Date: 14 August 2024
Our ref: 484225
Your ref: **Luton Airport Expansion**

**Planning Act 2008 and the Infrastructure Planning (Examination Procedure) Rules 2010
Application by London Luton Airport Limited (“the Applicant”) Seeking Development Consent for the Proposed London Luton Airport Expansion (“the Proposed Development”).**

CHILTERN NATIONAL LANDSCAPE (formerly Area of Outstanding Natural Beauty)

Drawing Title  
**Figure 14.7 Landscape and Visual Impact Assessment (LVIA) Constraints Plan**

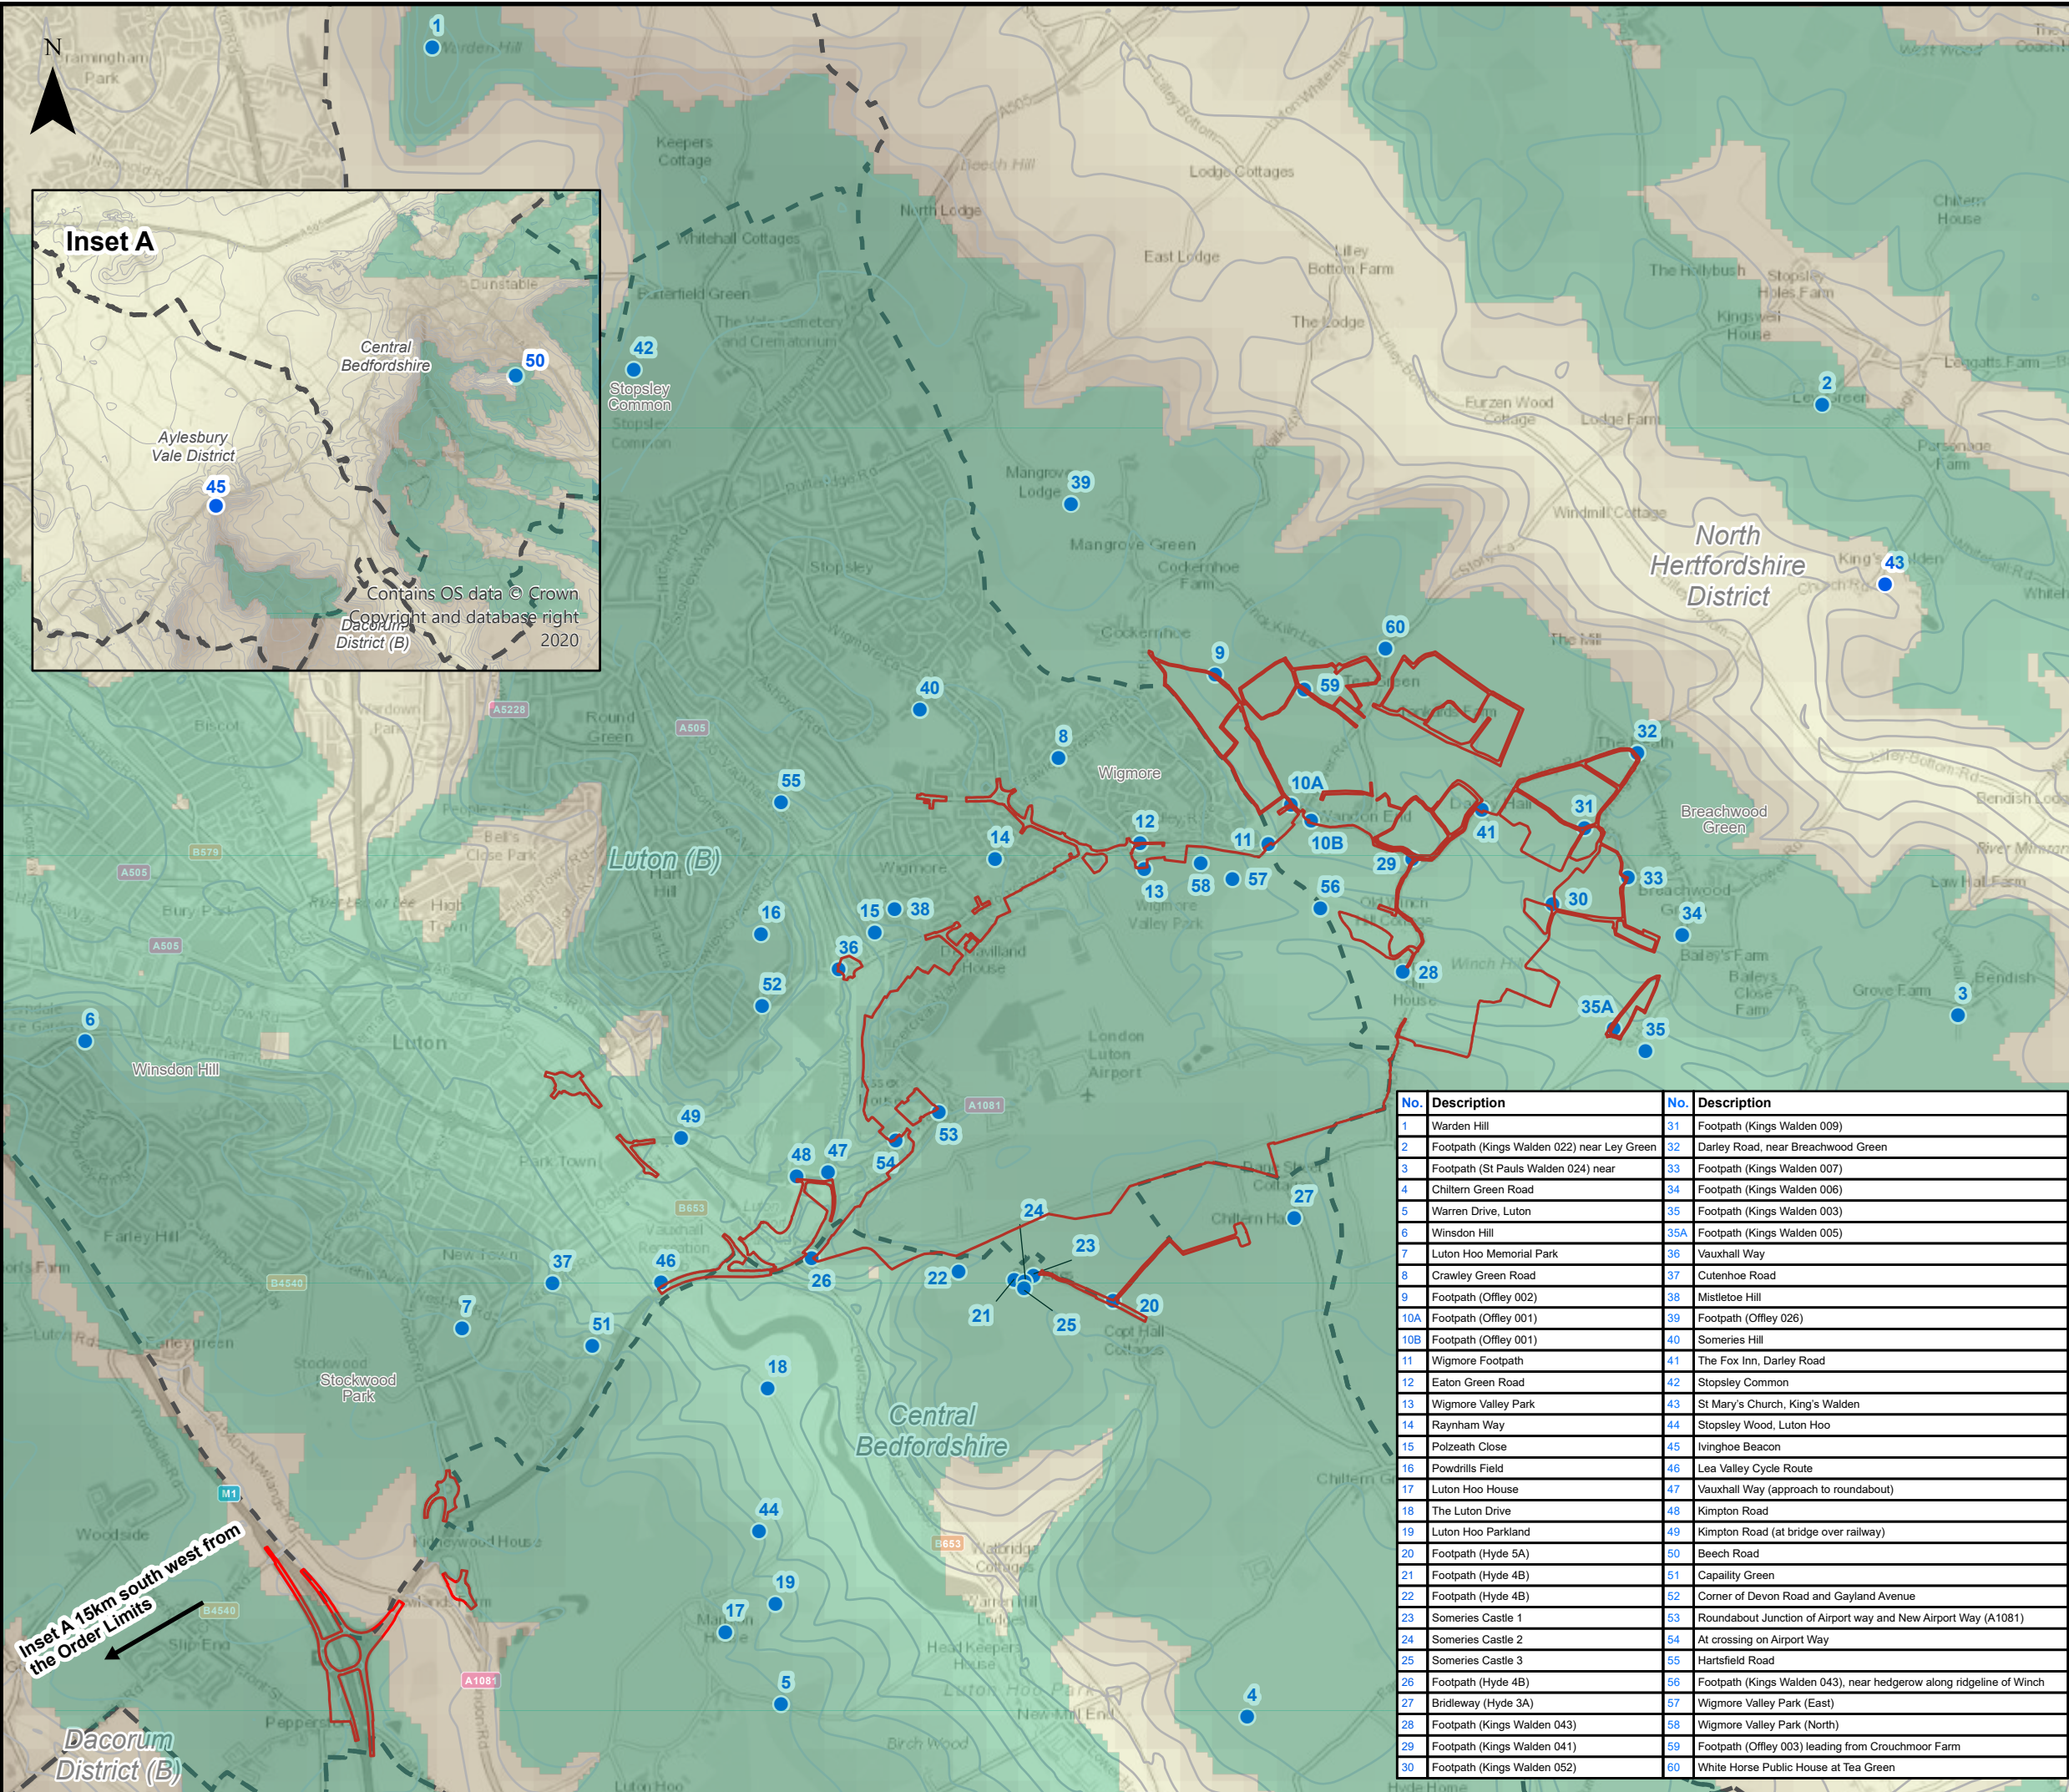
We would point out that the area indicated on Figure 14.7 ‘Landscape and Visual Assessment Constraints Plan’, drawing no: LLADCO-3C-ARP-00-00-DR-YE-0061, Revision 01 as a ‘Candidate Area for Chilterns Area of Outstanding Natural Beauty’ has not originated directly from Natural England and is incorrect. This area appears to show part of the ‘Area of Search’ for the project. At

However, we can confirm that we are we considering areas immediately to the east of the Order Limits as drawn in figure 14.7, and it is possible that there may be some slight overlap in particular locations between the red line Order Limits and Candidate Areas, once boundaries for these have been drawn.
